FW: BR/5/26/PL BNG revisions

Subject: BR/5/26/PL

35 Glamis Street Bognor Regis PO21 1DJ.

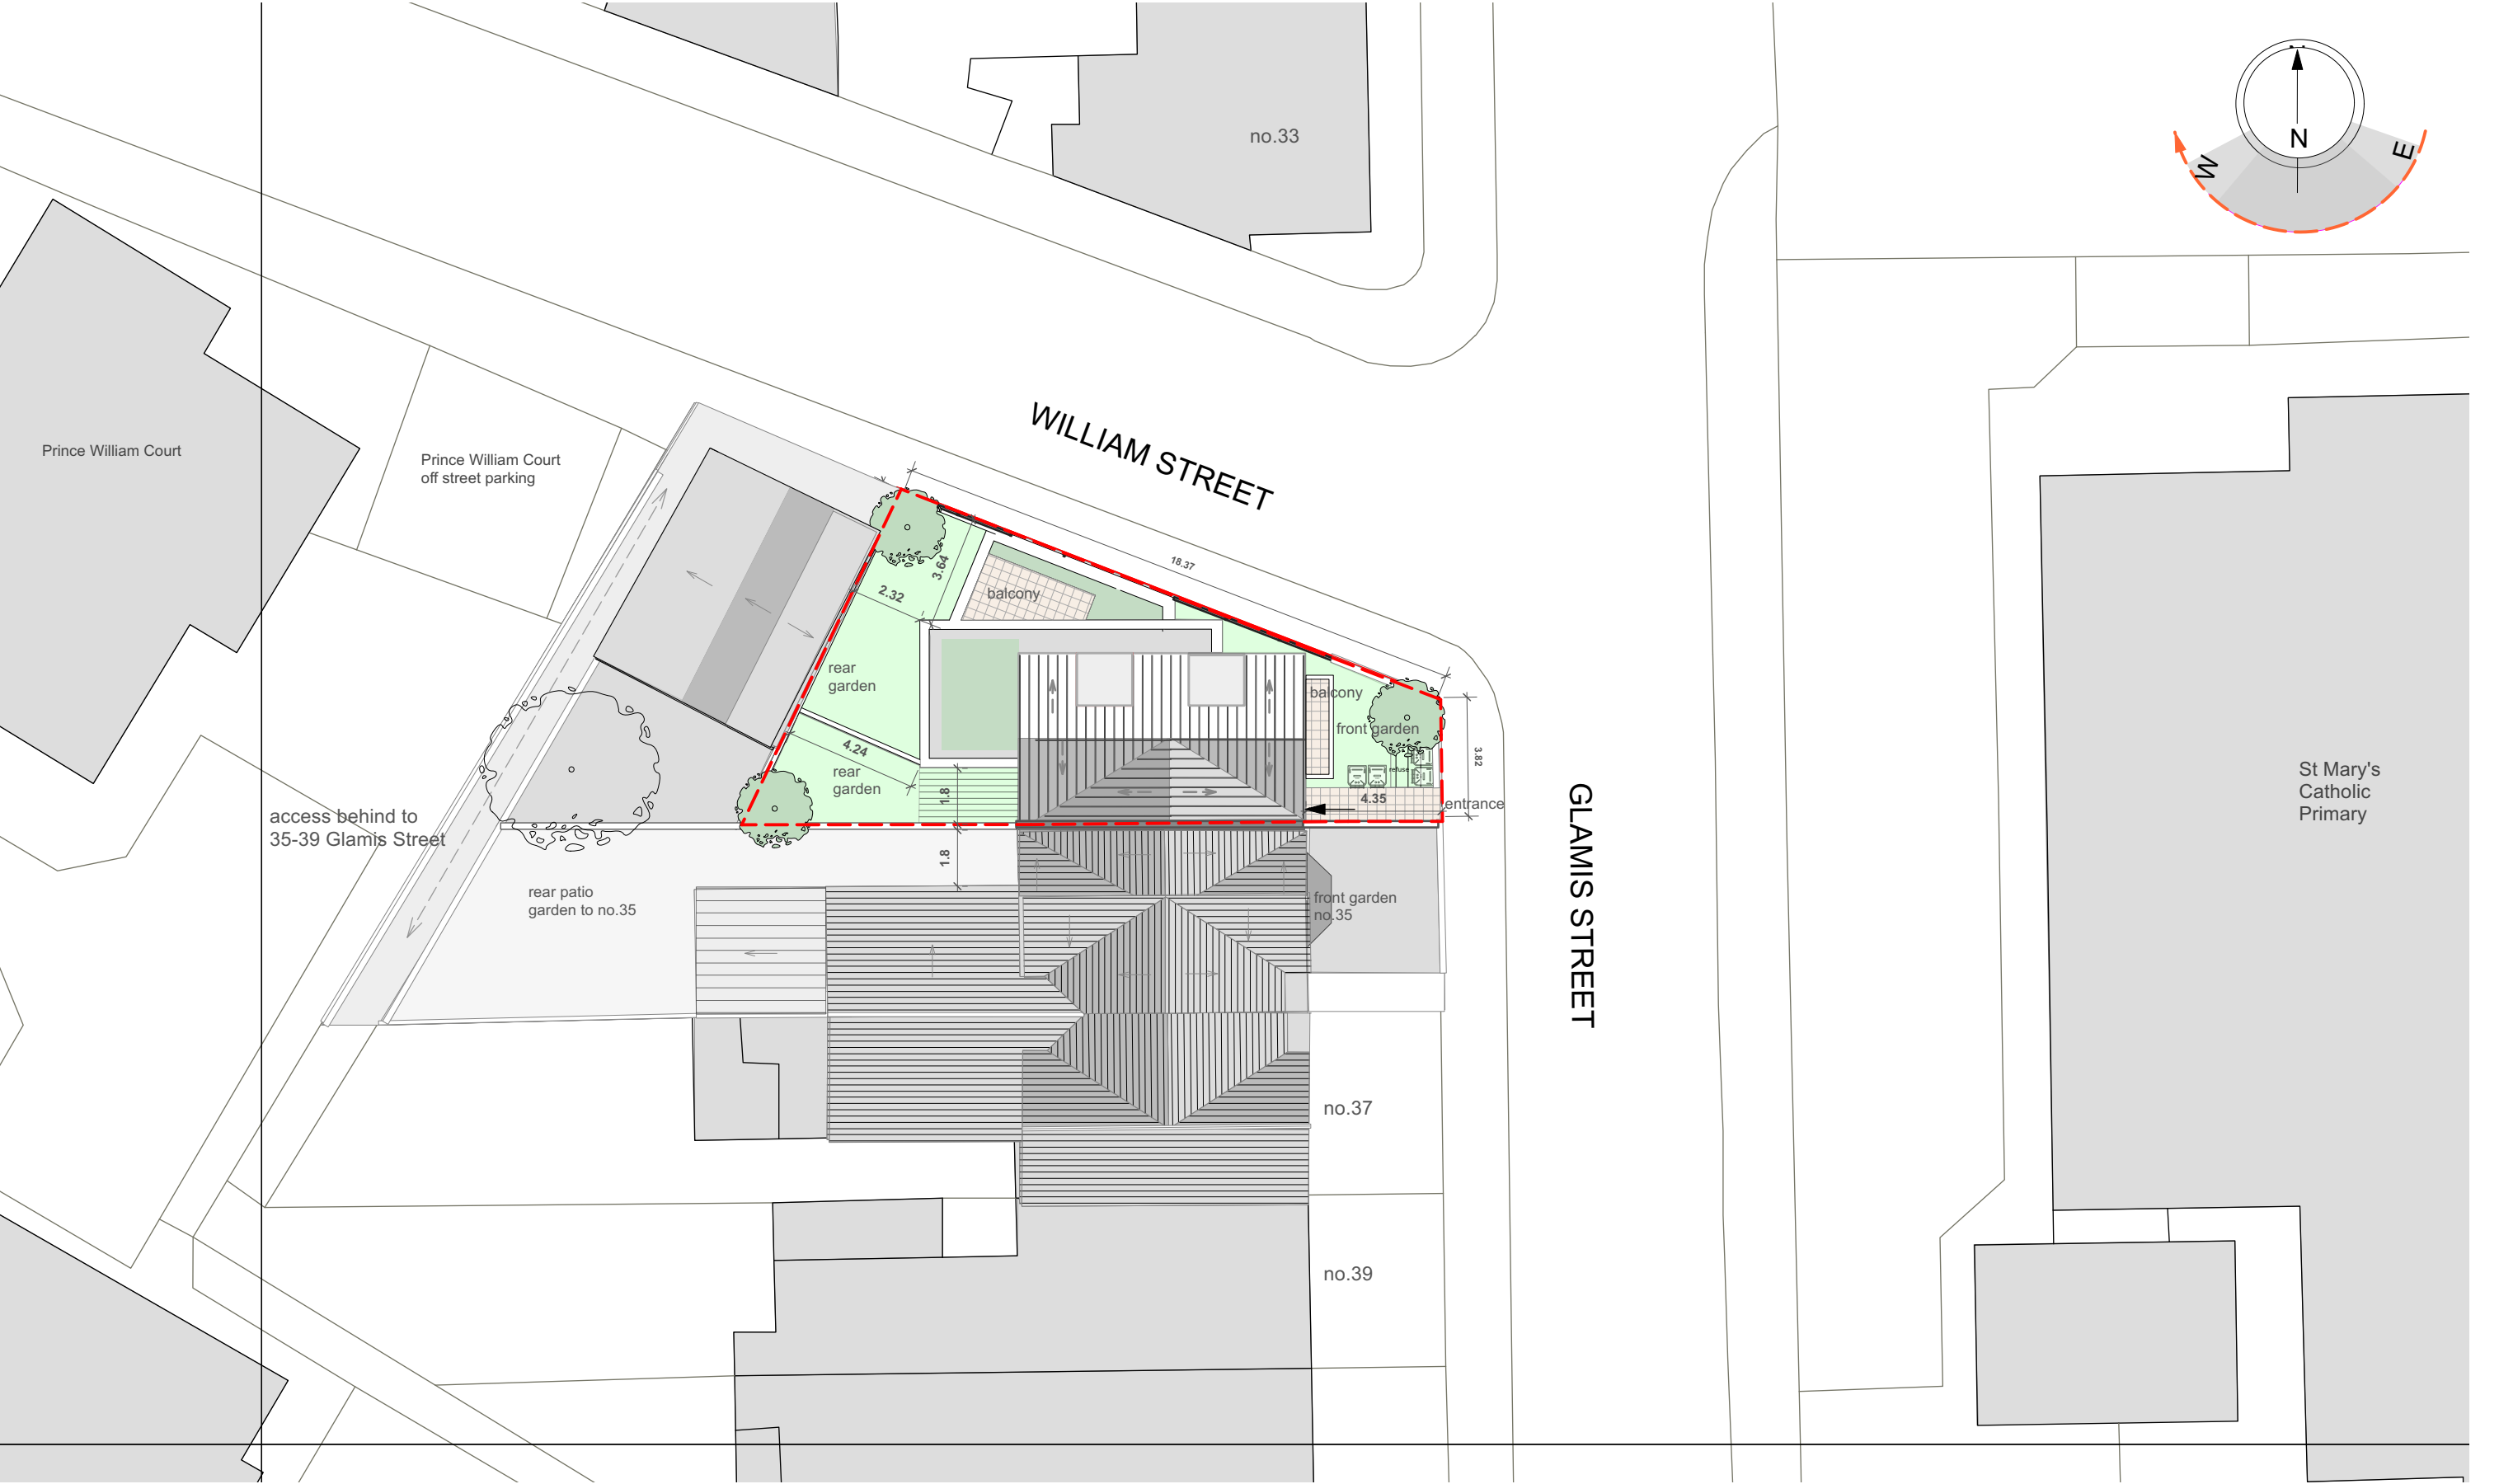
The provision of tree planting is welcomed but cannot count towards the post biodiversity unit value as it is located within private gardens.

Therefore, the gains recorded cannot be counted and consequently the gains are incorrectly calculated in this metric. A revised metric is required to show the post development BNG value. Offsite BNG may be required.

I have now included some of the sedum roof areas which were not listed before.

DESIGN DETAIL / MATERIALS

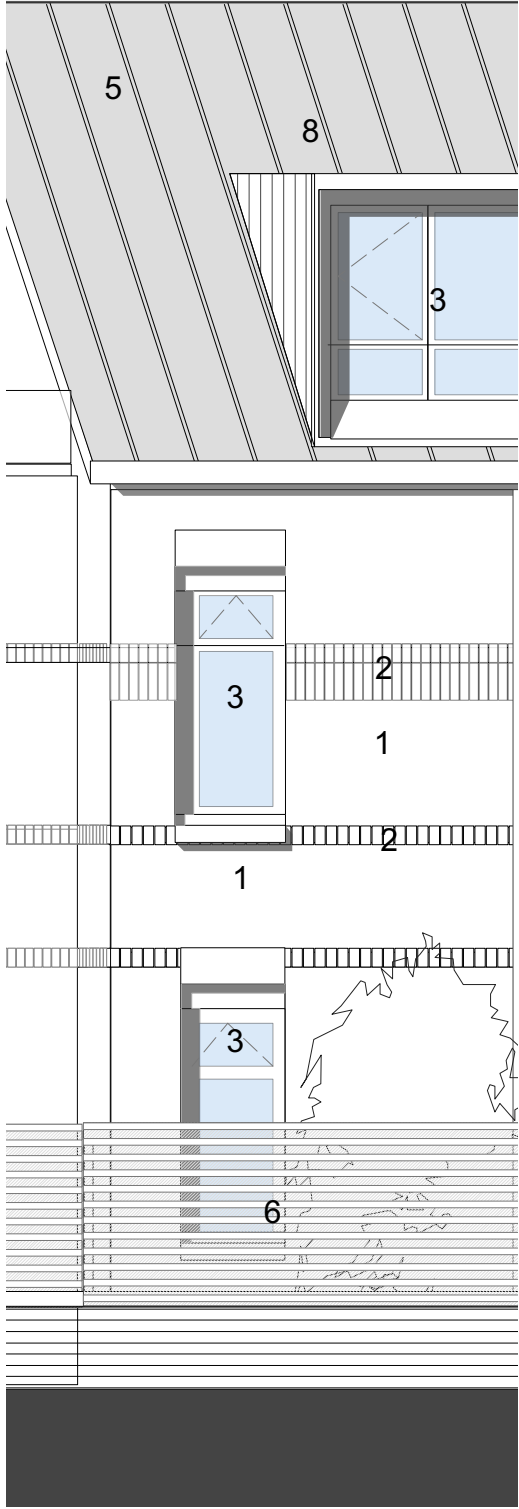
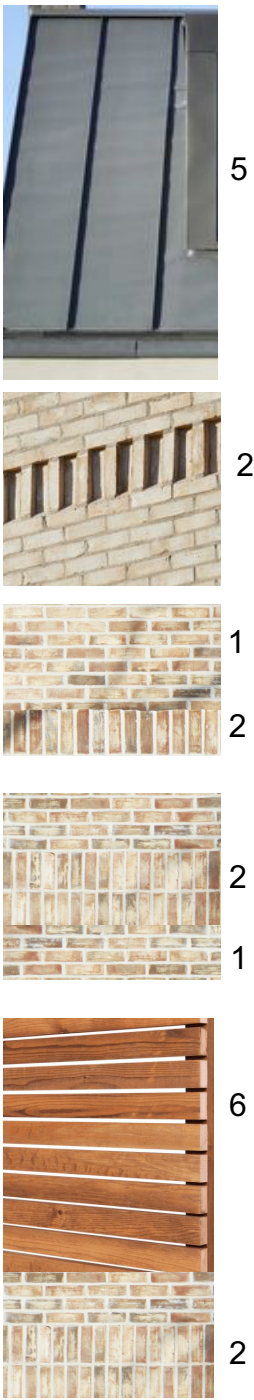
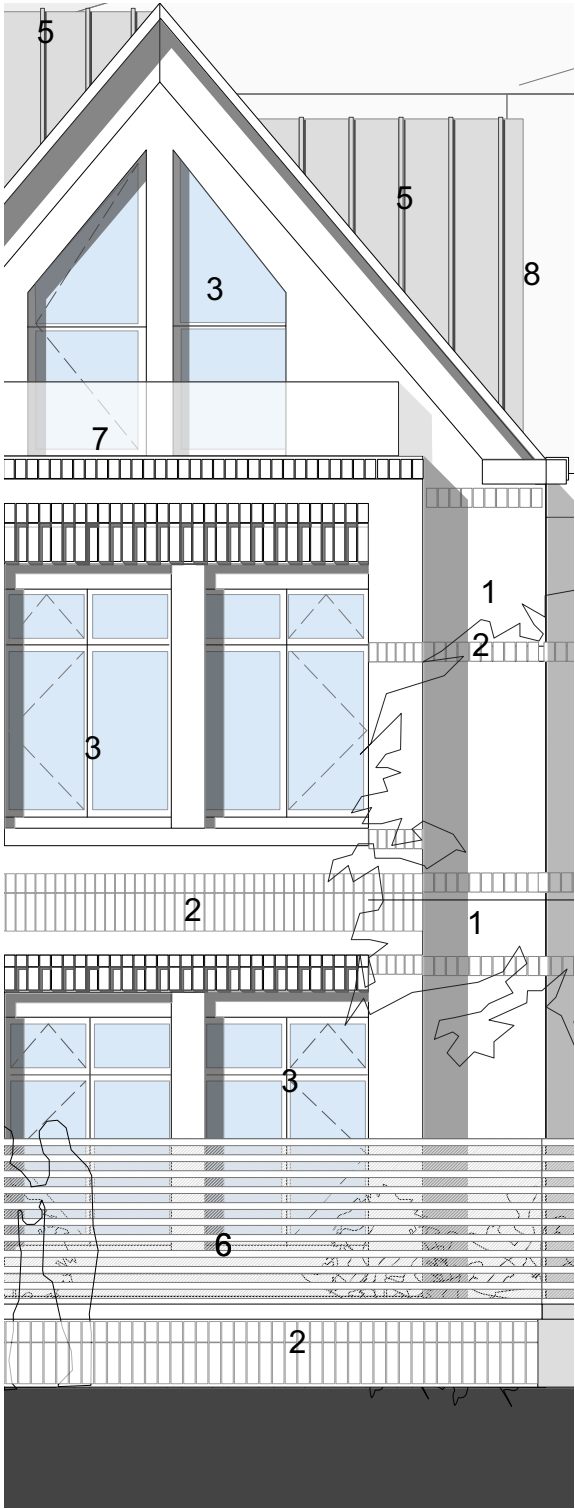
Ecological features are advised for the townhouse. A integral swift brick and a integral bat tube are advised.

I have reviewed the BNG metric and removed the 3 trees from calculation which were included before, and reviewed if any additional measures could be included.

We are happy to include the other suggested ecological features.
